## Appeal Decision

**Appeal Ref: APP/R5510/D/23/3326037**

**5 Greencroft Avenue, Ruislip HA4 9JG**

PROPOSED BLOCK PLAN

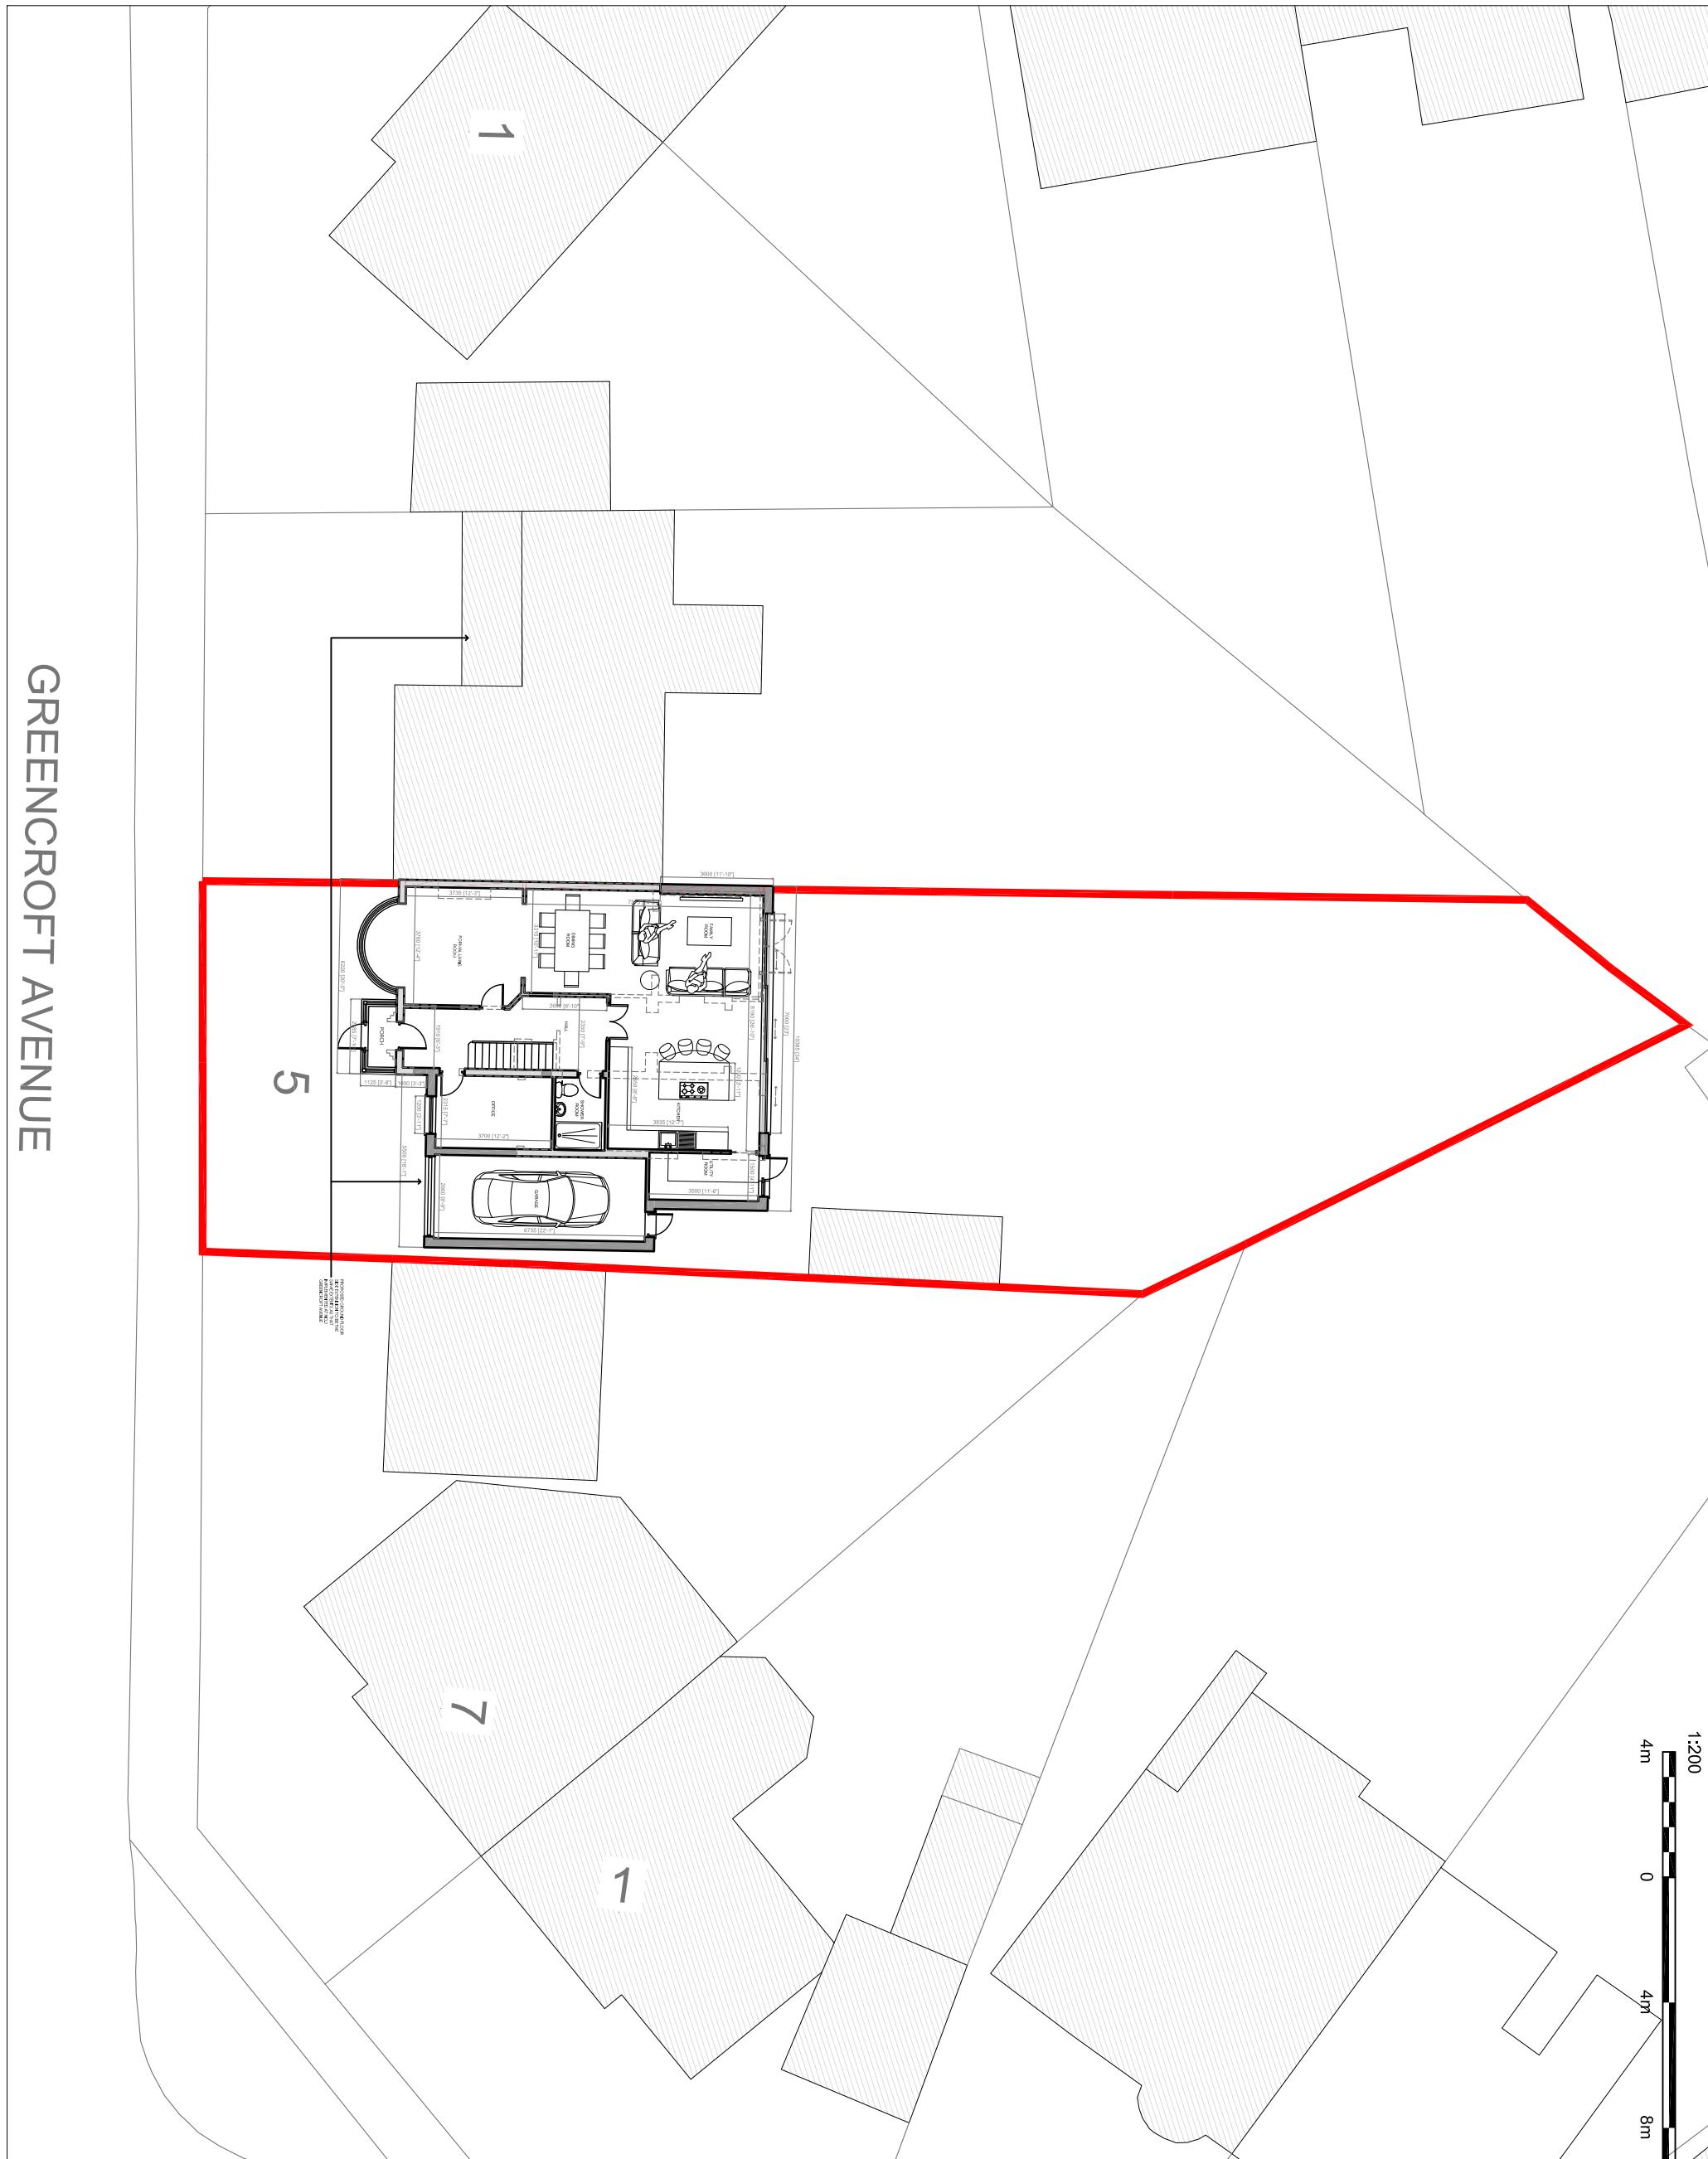
7. The property would appear over-extended in relation to the existing house and the pattern of development in the vicinity. I agree that the property sits on one of the more generous plots, in terms of width, but the additional width of the plot and relationship with the neighbouring property at No 7 would not enable the overprominent addition to the existing house to be readily assimilated into the street scene.

10. I have noted that the property at No 3 has been further extended but I do not consider that the proposal would introduce symmetry to the pair, as it would appear to be suggested by the Appellant. The proposal before me would bring two storey development much further forward in relation to the adjoining property at No 3 and would remain an overly prominent extension in relation to the semi-detached pair.
